WEST SUSSEX COUNTY COUNCIL CONSULTATION

TO:	Arun District Council FAO: David Easton
FROM:	WSCC Highways - Public Rights of Way
DATE:	12 February 2024
LOCATION:	Barnham, Eastergate, Westergate BEW Parcel SC1 Barnham
SUBJECT:	BN/11/22/OUT Outline application with all matters reserved (except for the A29 Realignment) for the demolition of existing structures and mixed use development to provide residential dwellings (Use Class C3), Care Home/Senior Living Accommodation (Use Class E/F2/Sui Generis), a Primary School plus open space, landscaping, drainage and all other associated ancillary works; and realignment of the A29 and early connection to existing A29 including construction of a new road carriageway, junctions and associated infrastructure. This application also lies within the parish of Aldingbourne, affects the setting of listed buildings, affects the character & appearance of the Eastergate Church Lane Conservation Area and affects a Public Right of Way. This application is the subject of an Environmental Statement. I have received further information on the above application which is accompanied by an Environmental Impact Statement. The information was received on 21st Dece

Figure 4.2: Indicative Access and Movement Parameters Plan (by JTP)

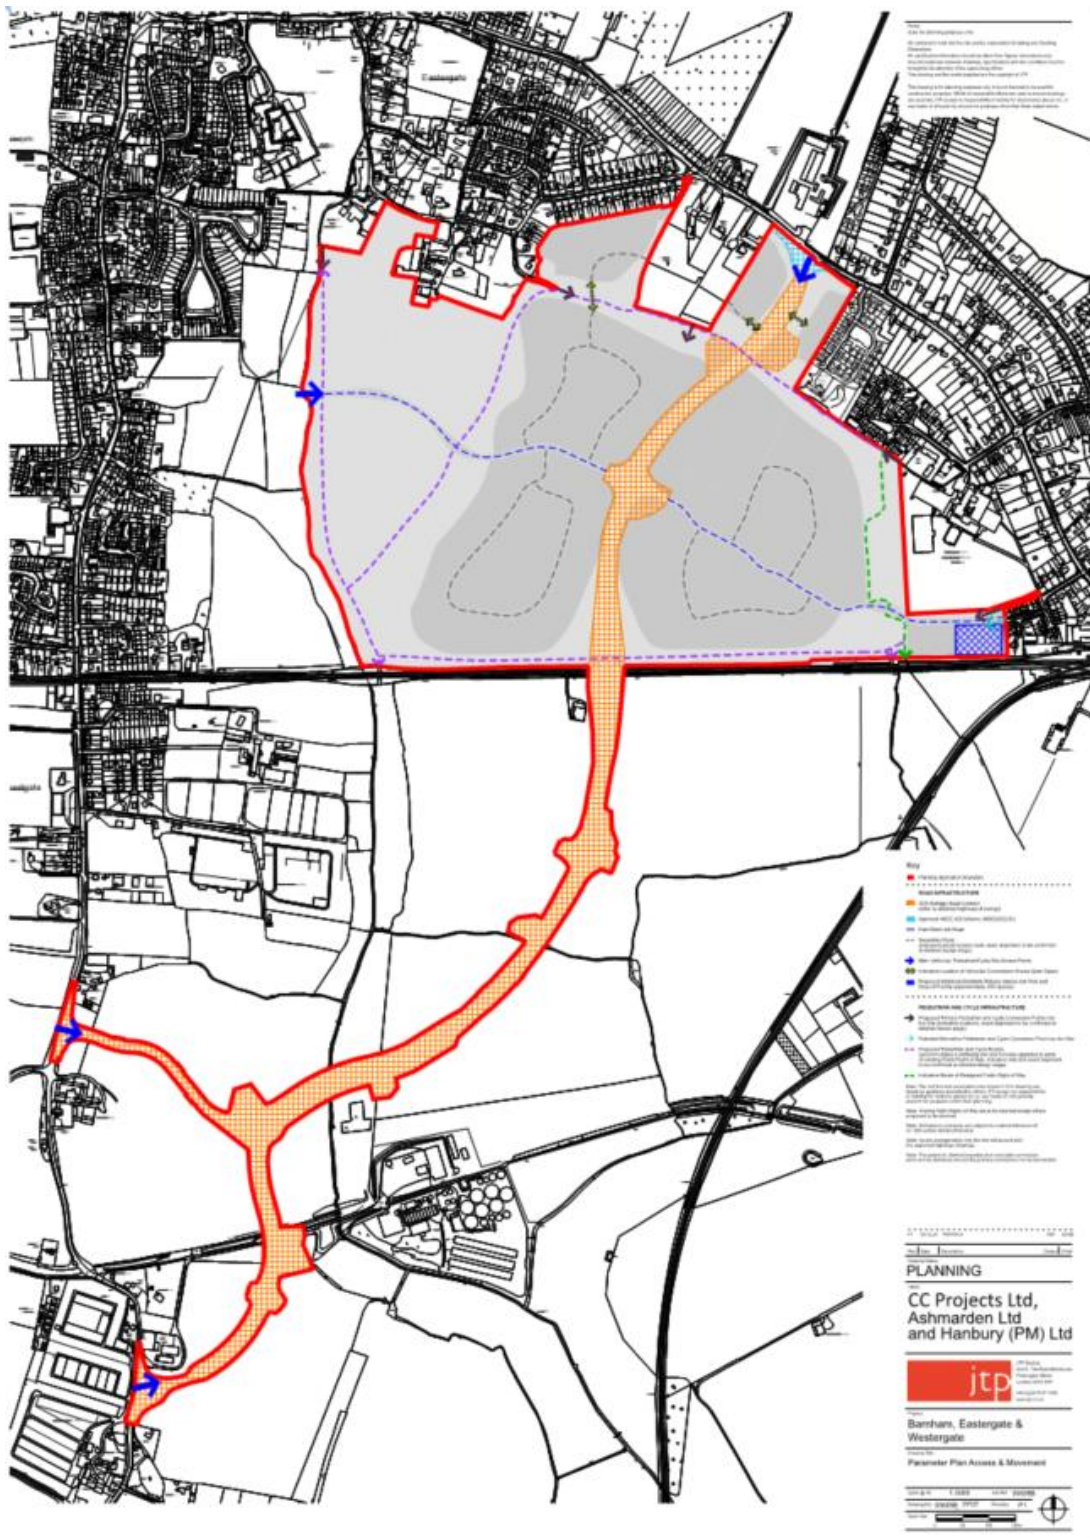
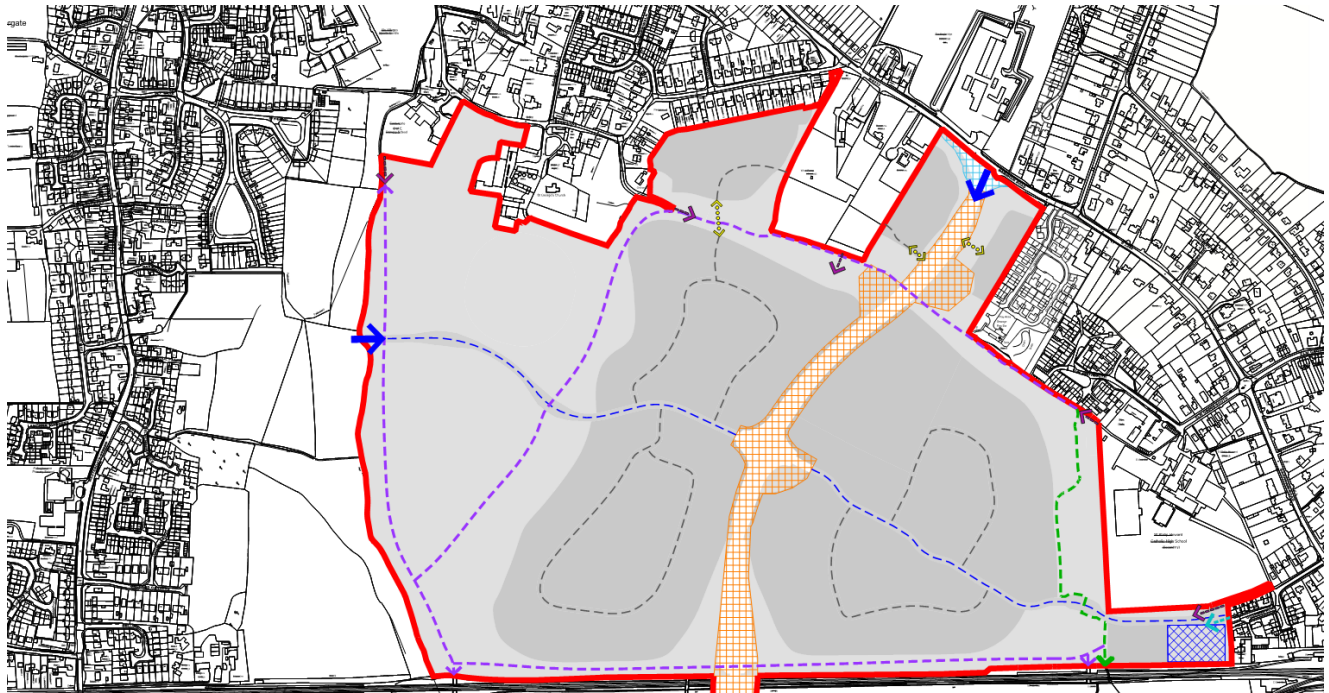
I am unsure if FP323 is also to be adopted under a S38 agreement (HA 1980) as suggested in the Supplementary Planning Statement or remain a PRow (with permitted cycle use) as indicated on the Environmental Statement Appendix 3 Parameter Plan Access and Movement 00605B_PP07 REVP3. Please clarify. The status will determine surface and width requirements, both of which will be delivered by the applicant, to be approved by either Highways or WSCC's PRow team. The diversion will be applied for through Arun District Council. Please ensure the diversion lines up with the diversion of FP323 through the new underpass. Highways will advise on the suitability of the north to south, at-grade island pedestrian and cycle crossing of the East-West Link Road.
